Project #: 1010328 Application #: 15DRB-70129  
Project Name: Volcano Cliffs Subd.  
Agent: Wilson & Company Inc. Phone #:

**CITY OF ALBUQUERQUE  
PLANNING DEPARTMENT  
January 7, 2015  
DRB Comments**

**RE: Lots 2 & 3, Block 6, Volcano Cliffs, Unit 18**

DEVELOPMENT REVIEW BOARD – SPEED MEMO

**LOT SPLIT
SHEET 2 OF 2**

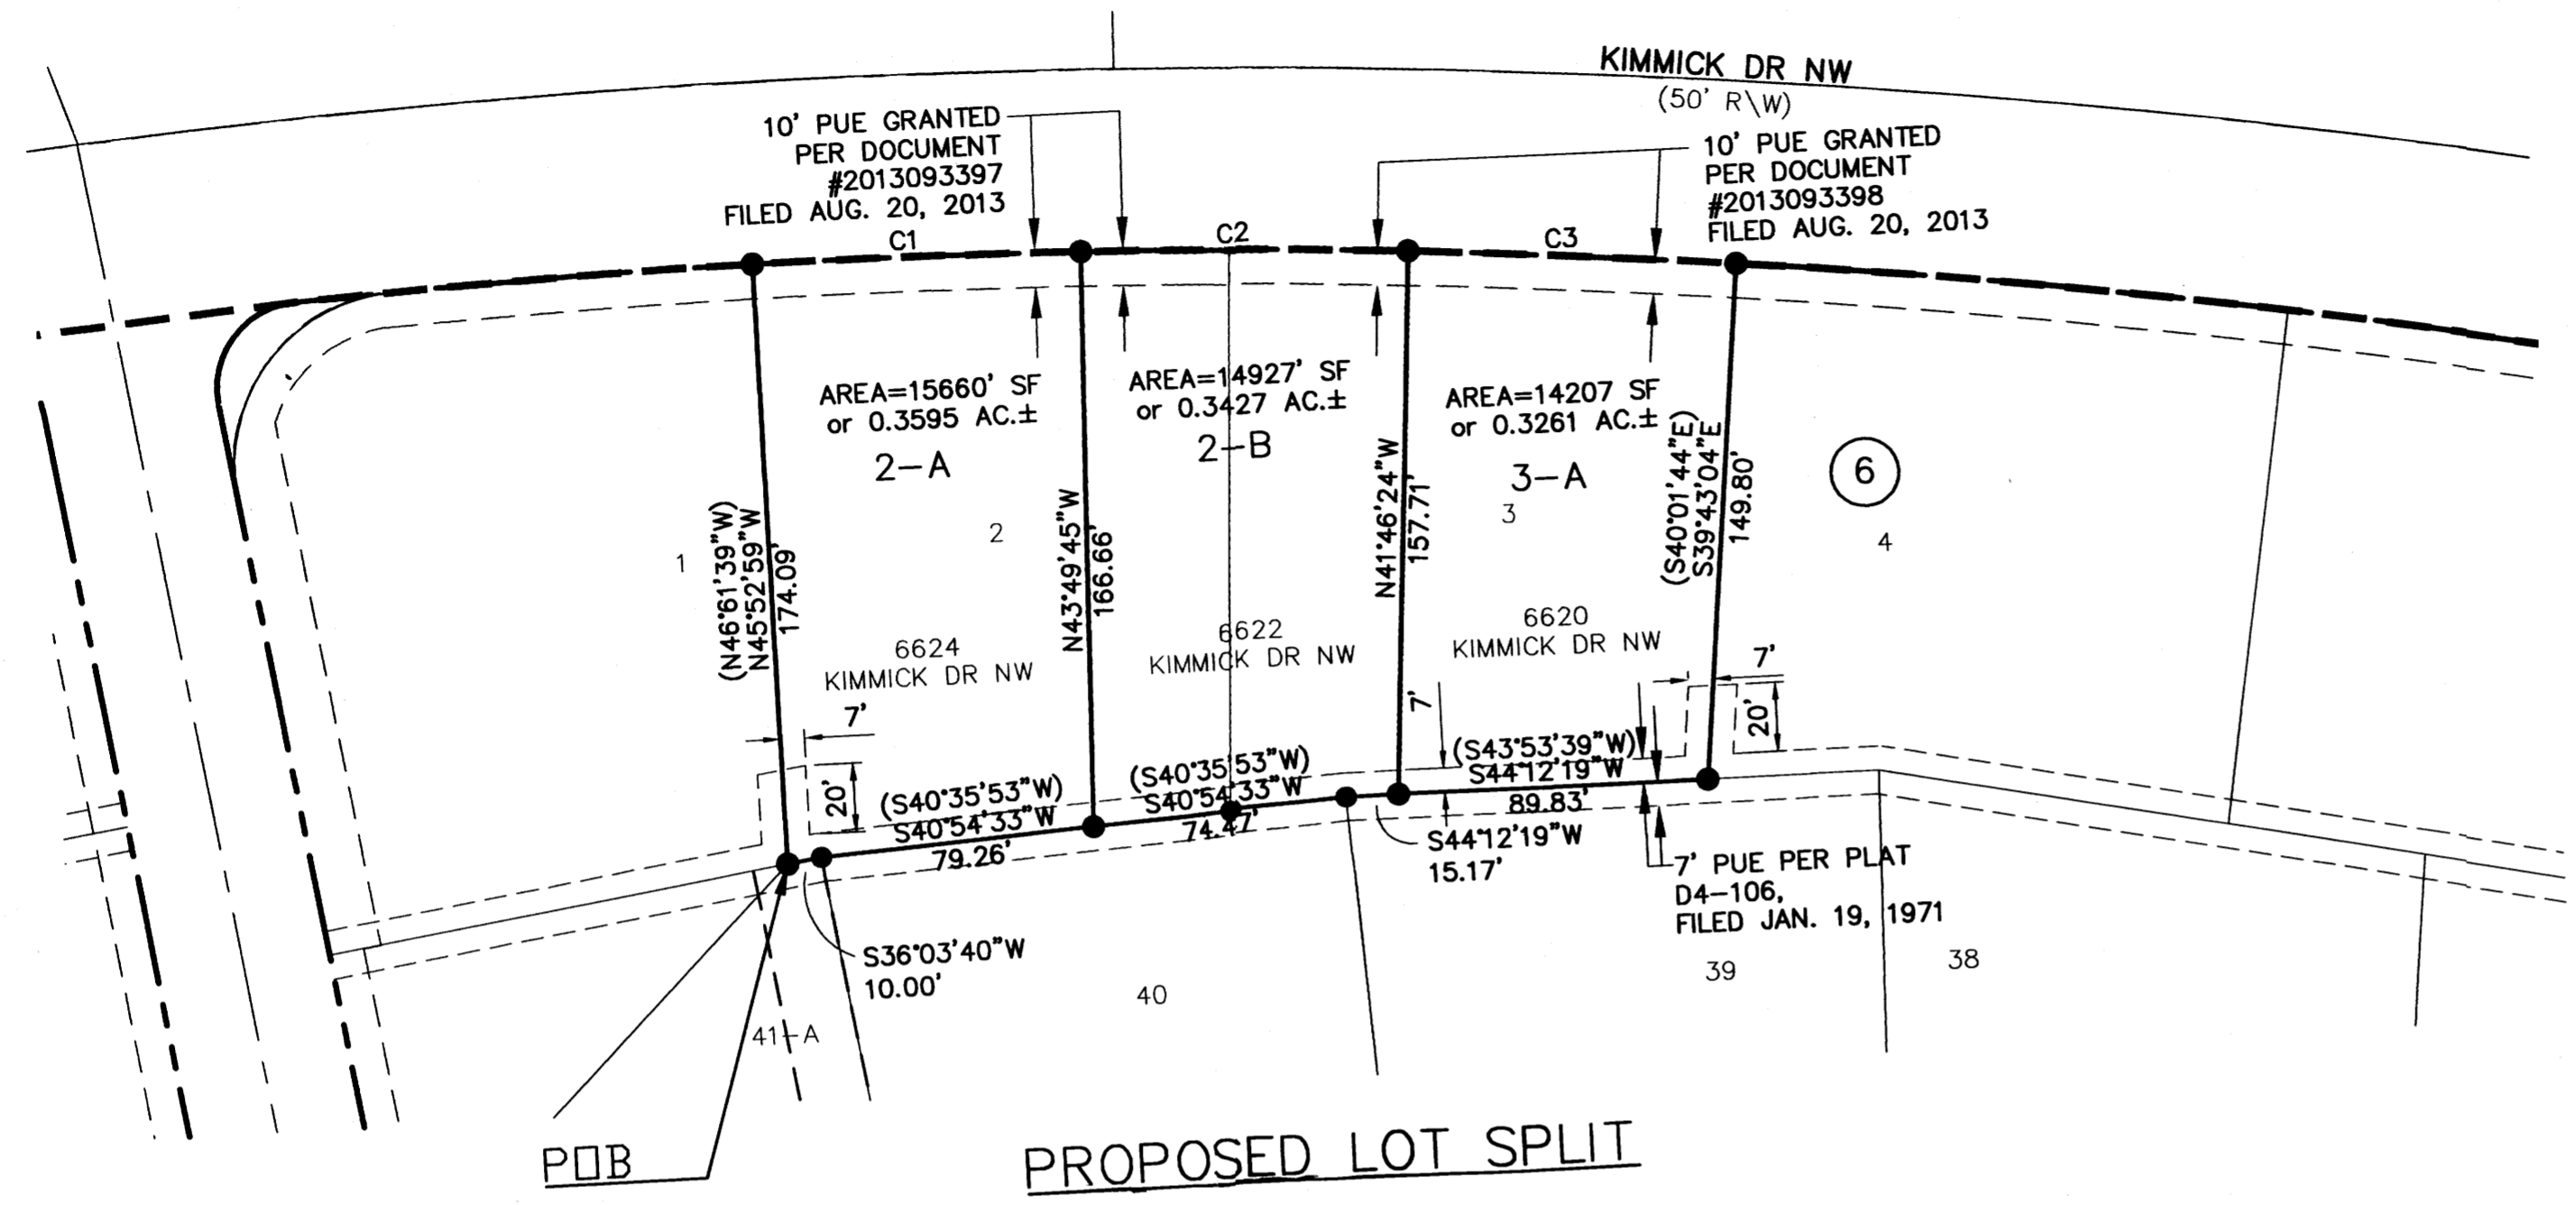
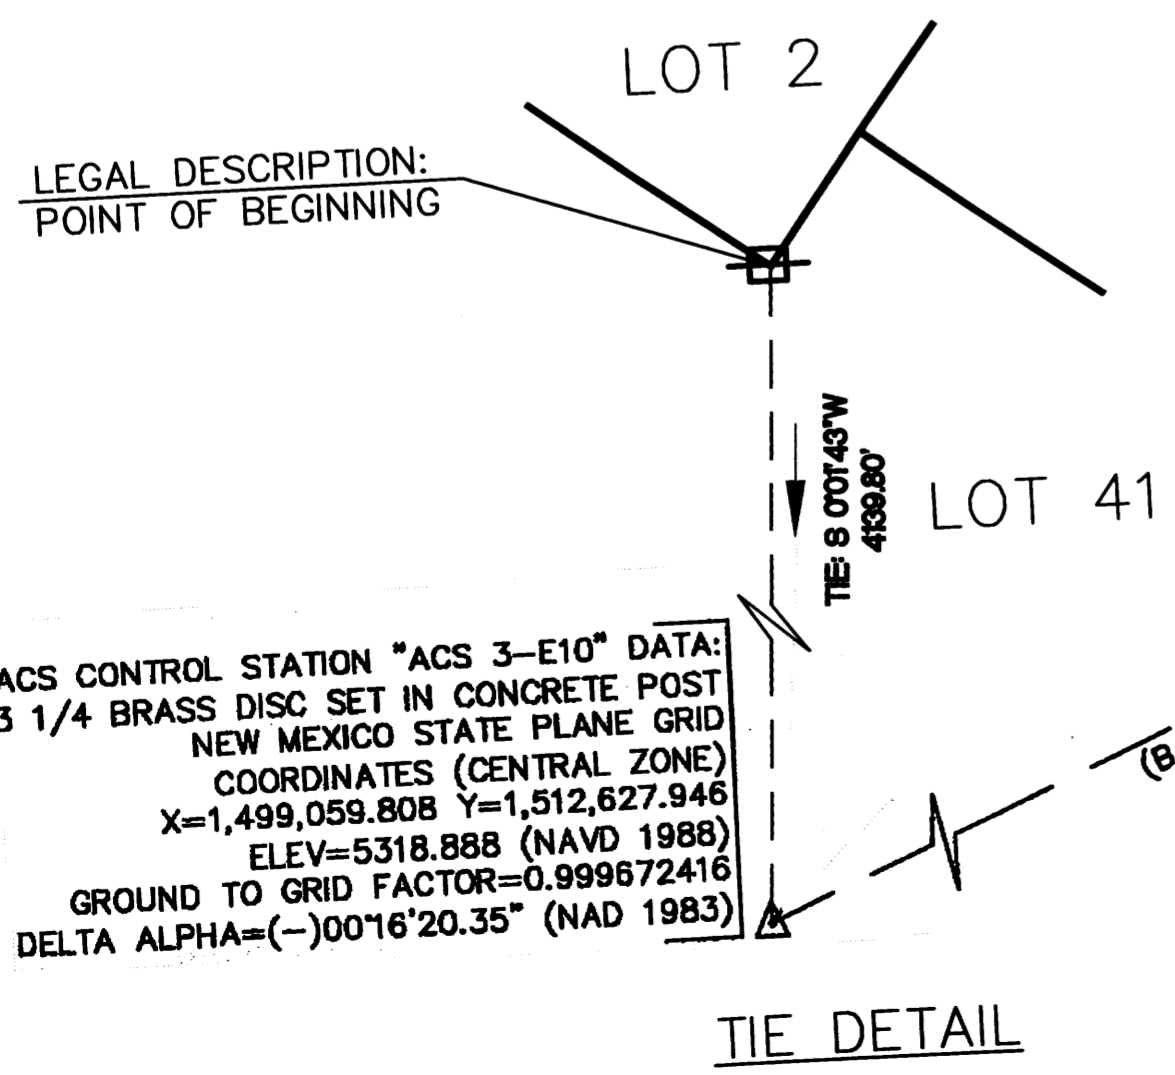
The site is zoned SU-2 VCLL; refer to NW Mesa Escarpment Plan/Impact Area & Volcano Cliffs Sector Development Plan for development standards (25' front setback and 15' for side and rear setbacks, bldg. articulation, bldg. height, garages, etc.).

Provide an exhibit showing the location of sidewalk and defining the distance from back of curb to the property line. Right of way dedication may be required.
